Your Ref :
Our Ref : F/7/13/NMA

Application for a non-material amendment following a grant of planning permission F/13/12/ for a variation of roof pitch to accommodate tiles and narrowing of door opening to door at front of proposed garage
2 Old Station Cottages, Ford Road, Ford,

PROPOSED NORTH VIEW 1:100

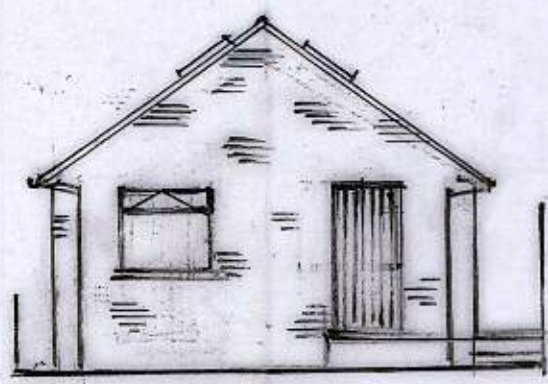
I refer to your recent application for a Non Material Minor Amendment. From the information submitted I can confirm that the changes which include an increase in height of the building by 600mm, the reduced width to the opening on the south elevation and the repositioning of the door and window to the north elevation can be accepted as a minor amendment to the approved scheme. Please note that these plans therefore become the approved plans for F/13/12.
